Appeal Decision

Appeal Ref: APP/R5510/D/22/3294610

62 Fairacres, Ruislip HA4 8AW

- The appeal is made under section 78 of the Town and Country Planning Act 1990 against a refusal to grant planning permission.
 - The appeal is made by Mr V Santos against the decision of the London Borough of Hillingdon.
 - The application Ref: 24895/APP/2021/3803, dated 11 October 2021, was refused by notice dated 21 December 2021.
 - The development proposed is alterations to games room to form home office/gym and single storey rear extension.
-

DWG No
03
Rev: - b

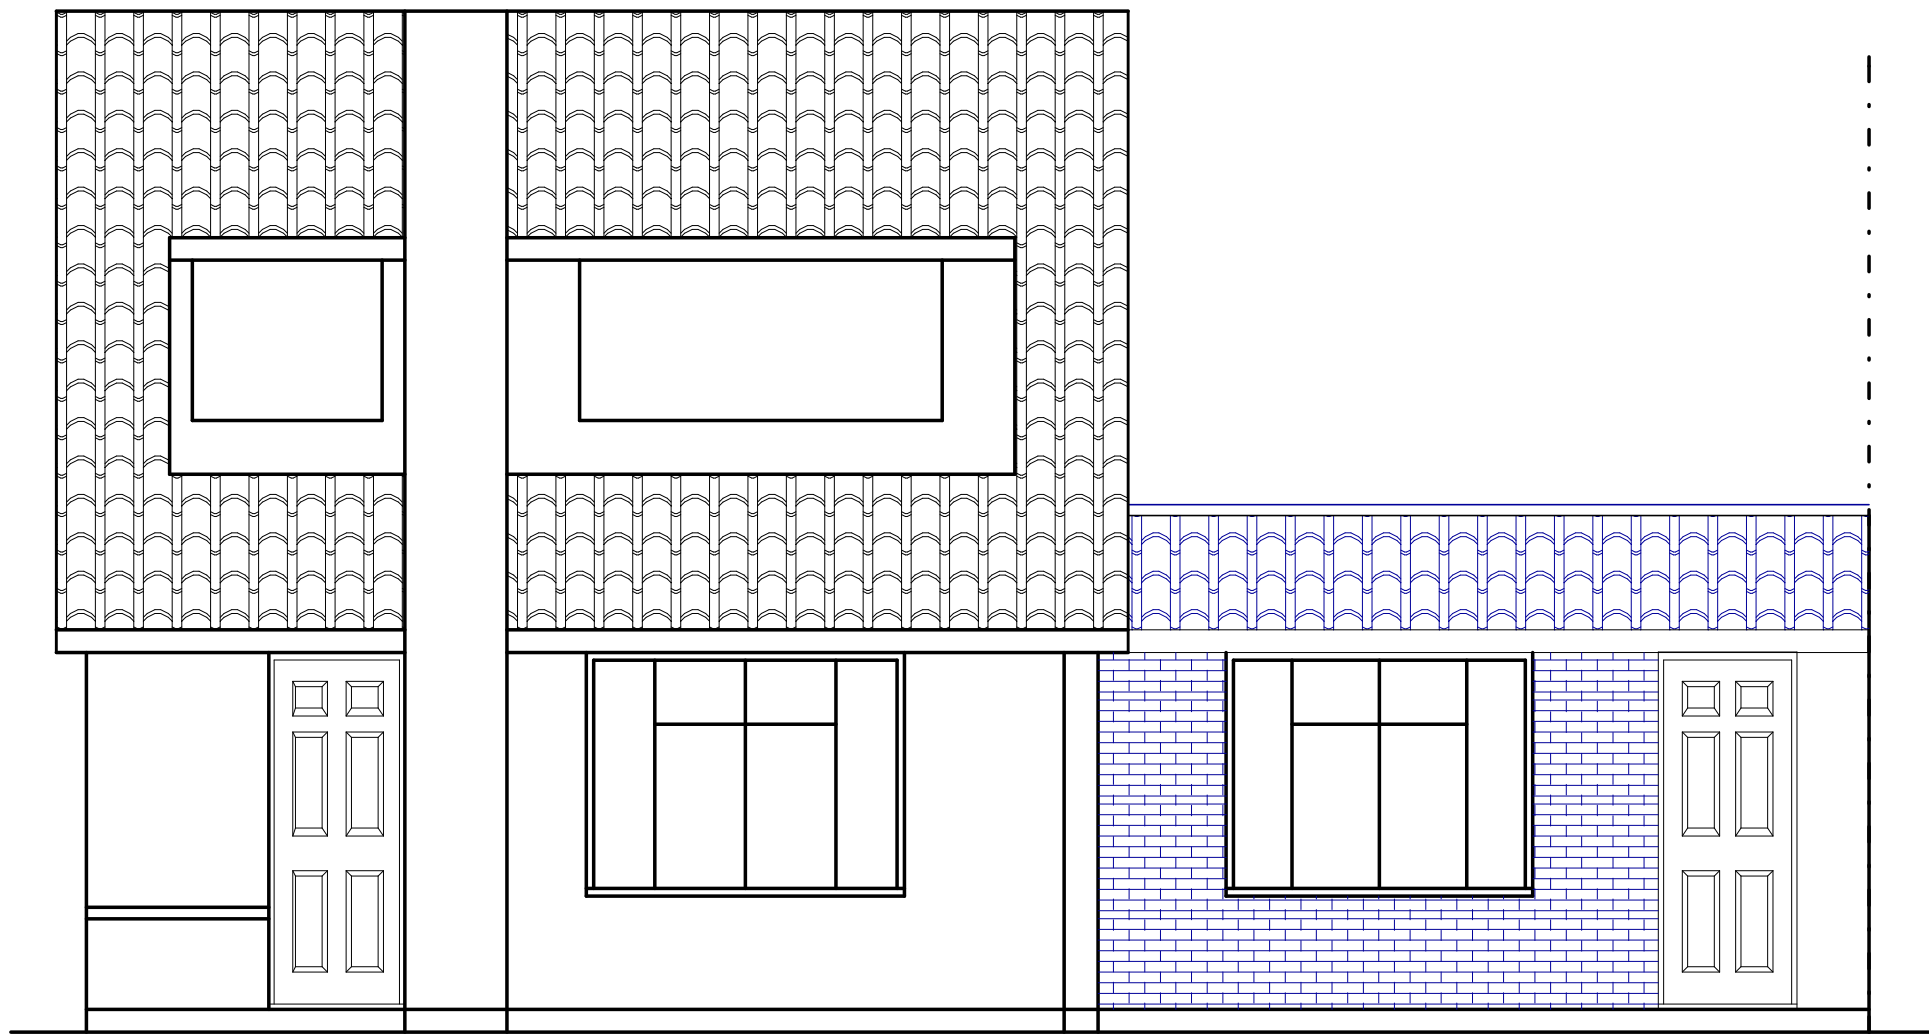
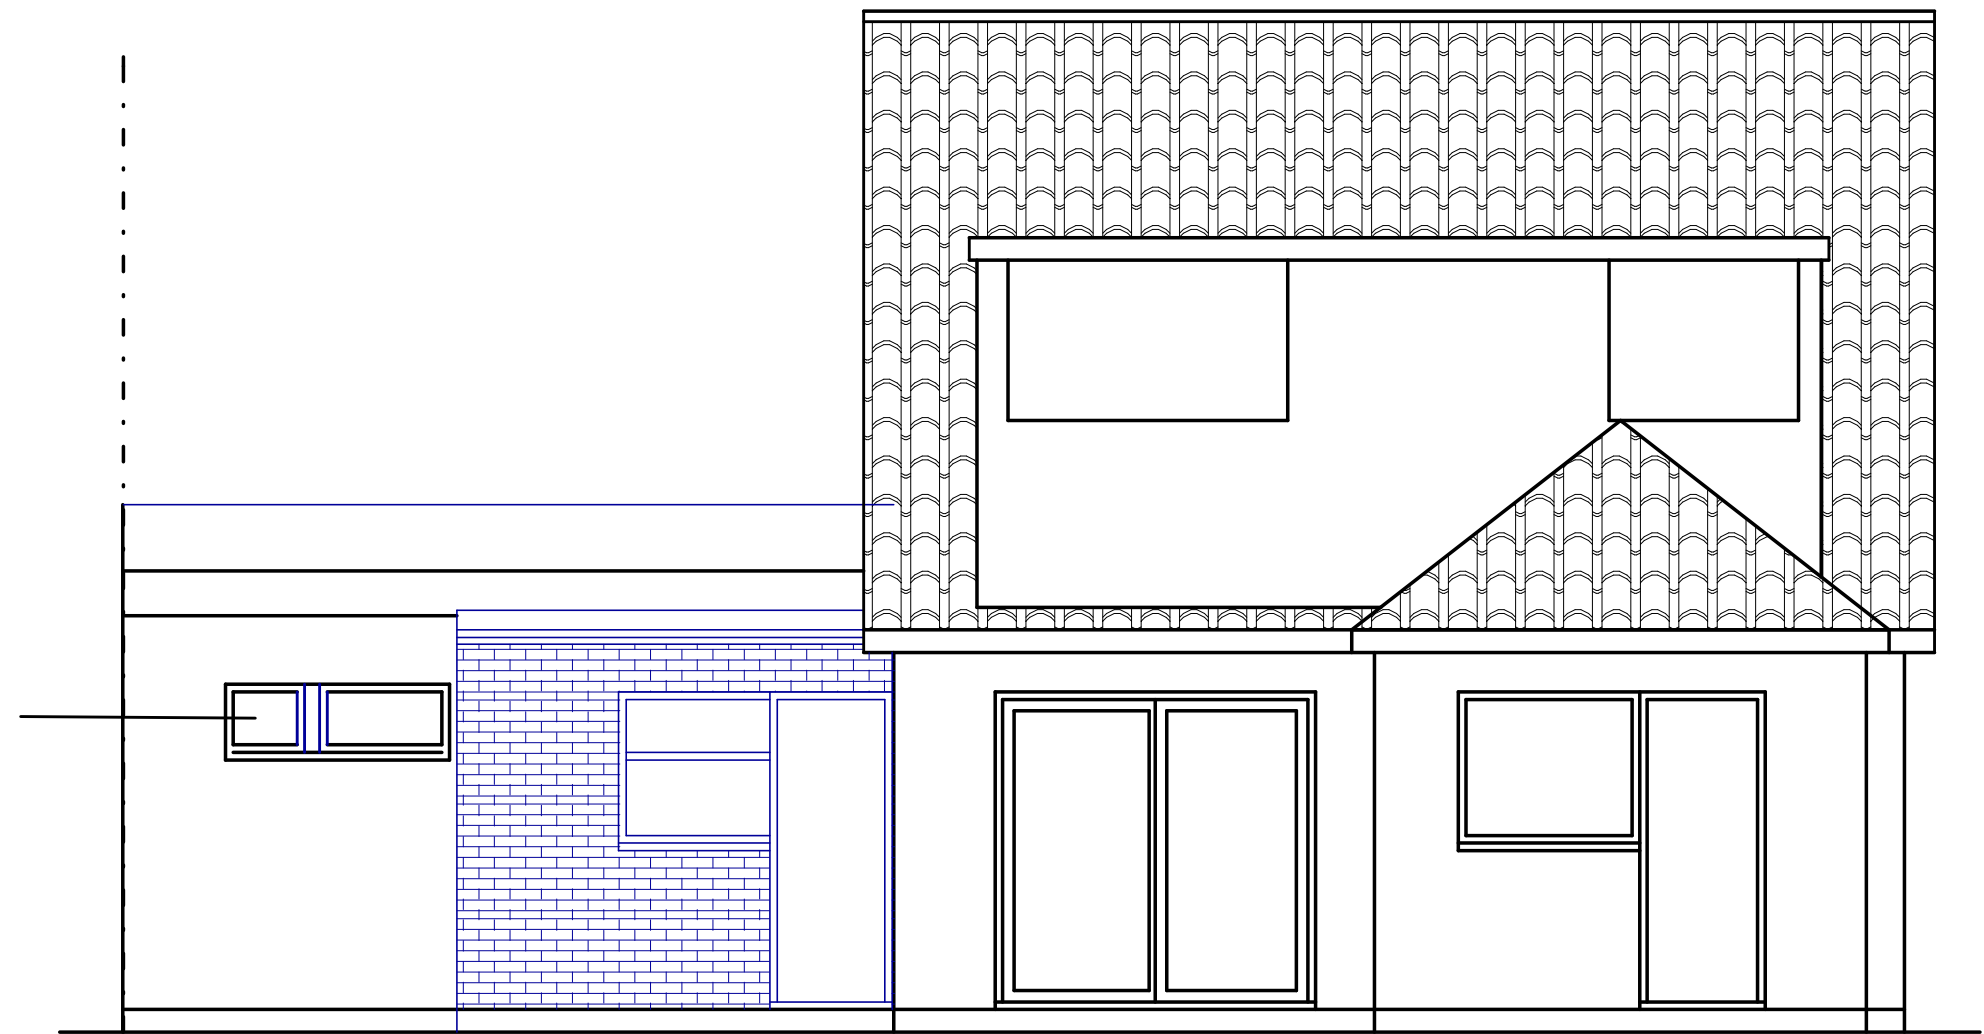
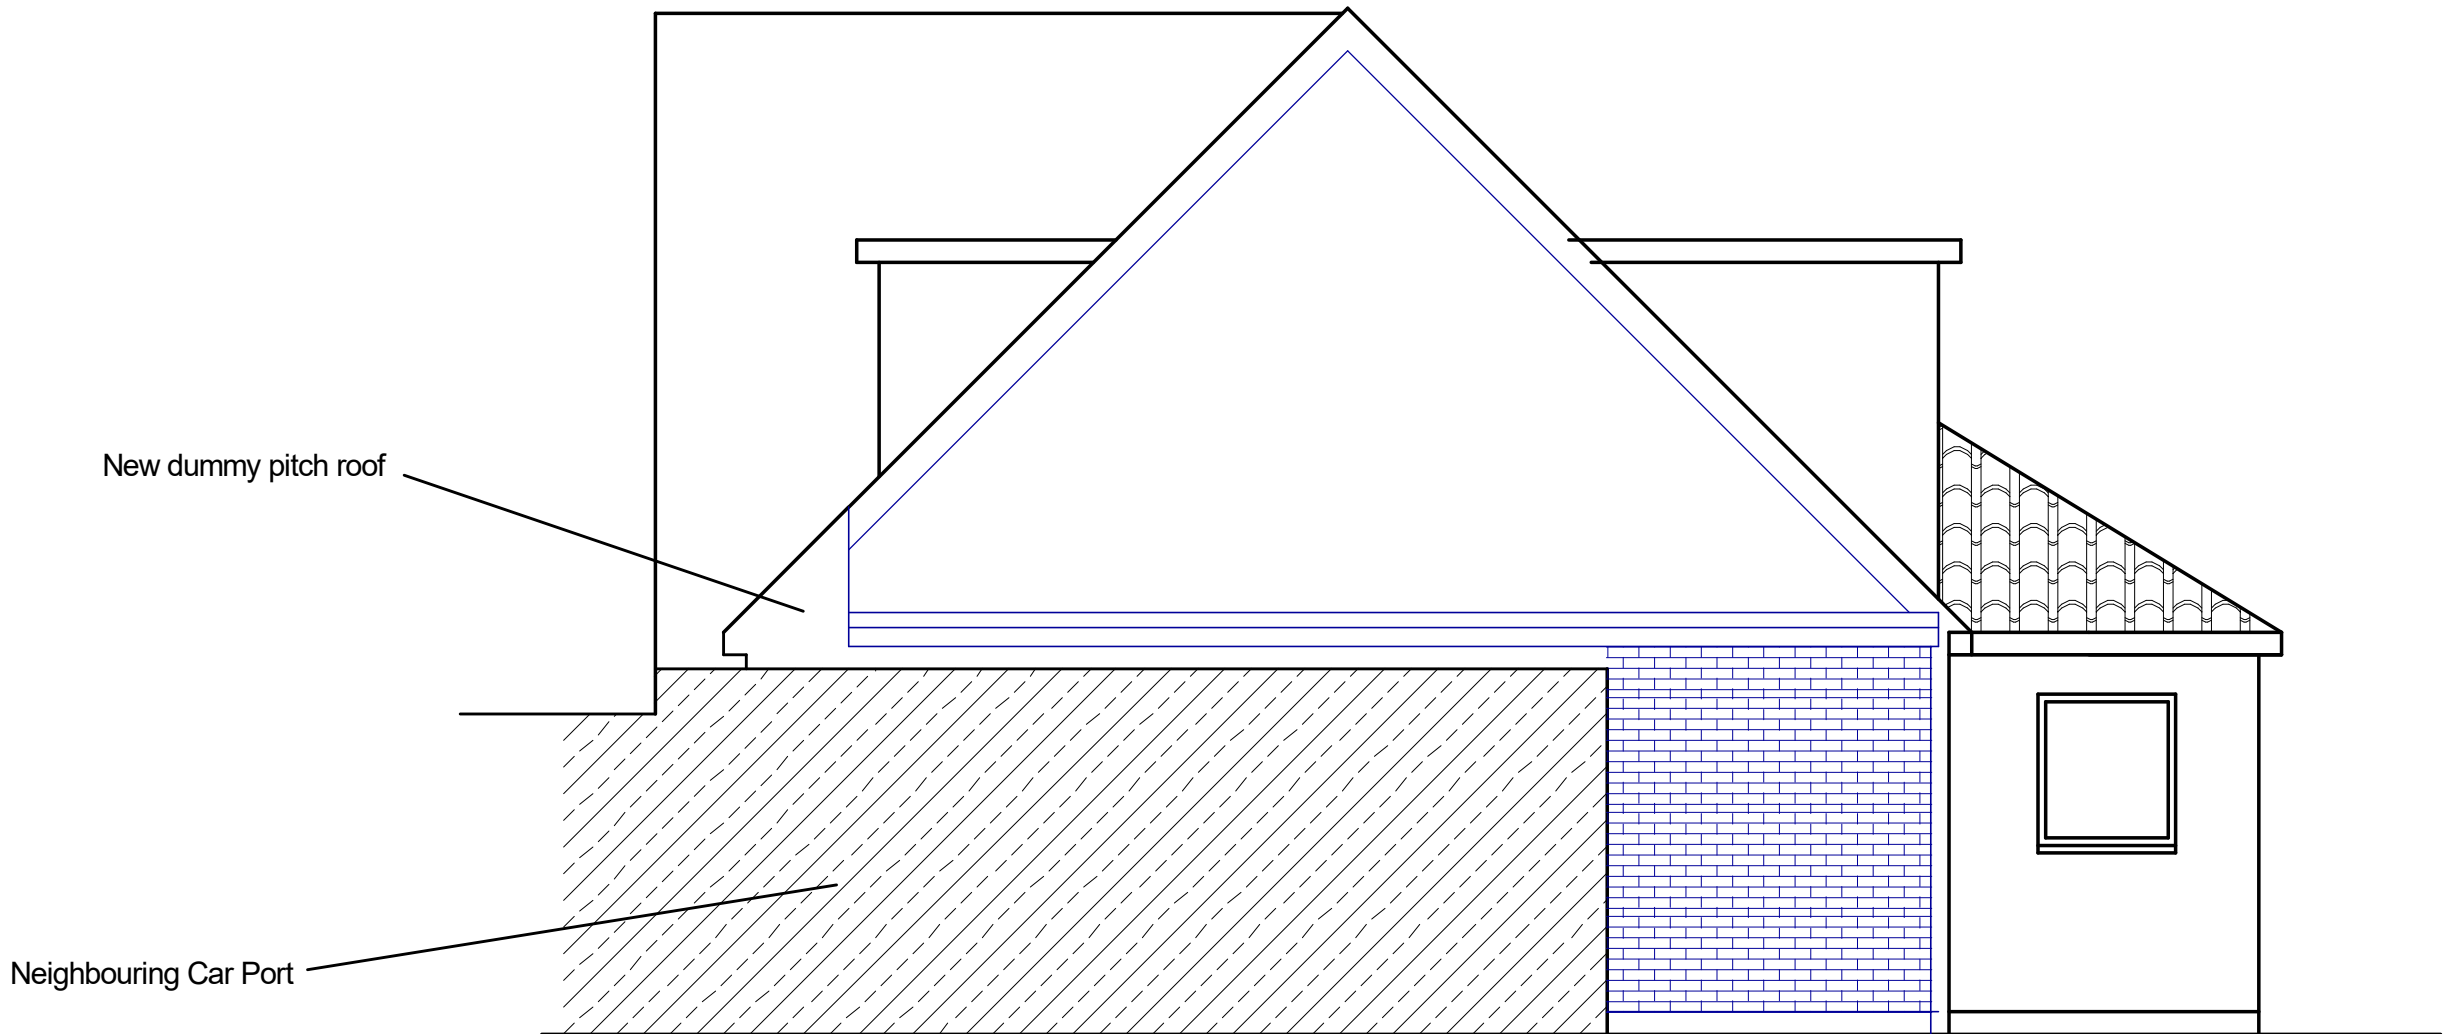
6. The proposed development involves alterations to the front of the single storey games room, including the replacement of the existing garage door with a bay window and additional door with a brick surround.

7. The proposal would alter the appearance of the property, perceptibly enlarging the area of habitable accommodation. Nevertheless, I observed on my site visit that a number of other properties on Fairacres and in the wider area have converted garage spaces into habitable accommodation and introduced fenestration into these parts of the dwellings. The complementary form and design of the proposed additional fenestration and door to No 62, along with the use of matching materials, would assist the proposal's assimilation with the main part of the property and its integration within the street scene.

8. I am aware that additional front doors are not evident on any other property on Fairacres. However, they are present on buildings nearby on Evelyn Avenue, being part of schemes that are visible from public routes and which were granted approval by the Council¹. Moreover, the positioning of the proposed additional door to No 62 would provide sufficient separation from the main front door and porch to the property to ensure that it would be read as a secondary entrance.

12. At the rear of the 'games room' are fixed and obscured glass blocks that face directly into the garden of No 65 Evelyn Avenue (No 65), and which are currently partly screened by an adjacent shed. The proposed alterations to form a home office/gym include the replacement of the glass blocks with opening, obscurely glazed, windows which would serve the gym and shower.

13. Given that the shed could be removed from its current position at any time, the location and opening nature of the proposed windows would have the potential to result in real and perceived overlooking into the private amenity space of No 65. This would lead to a loss of privacy by the property's occupants which would harm their living conditions.

- 4) The home office/gym hereby permitted shall not be occupied until the windows within the gym/shower (facing the garden of No 65 Evelyn Avenue) have been fitted with obscured glazing and no part of those windows that is less than 1.7 metres above the floor of the room in which they are installed shall be capable of being opened. Those windows shall be bottom hinged and only able to open inward. Once installed, the obscured glazing along with the bottom hinged and inward opening form of the windows shall be retained thereafter.

14. Nevertheless, I am satisfied that this issue could be adequately addressed by the imposition of an appropriately worded condition that would control the obscure glazing as well as the height of opening and form of opening of the proposed windows. This would satisfactorily mitigate the potential for any overlooking into the private amenity space of No 65, ensuring that there would be no loss of privacy by the property's occupants.
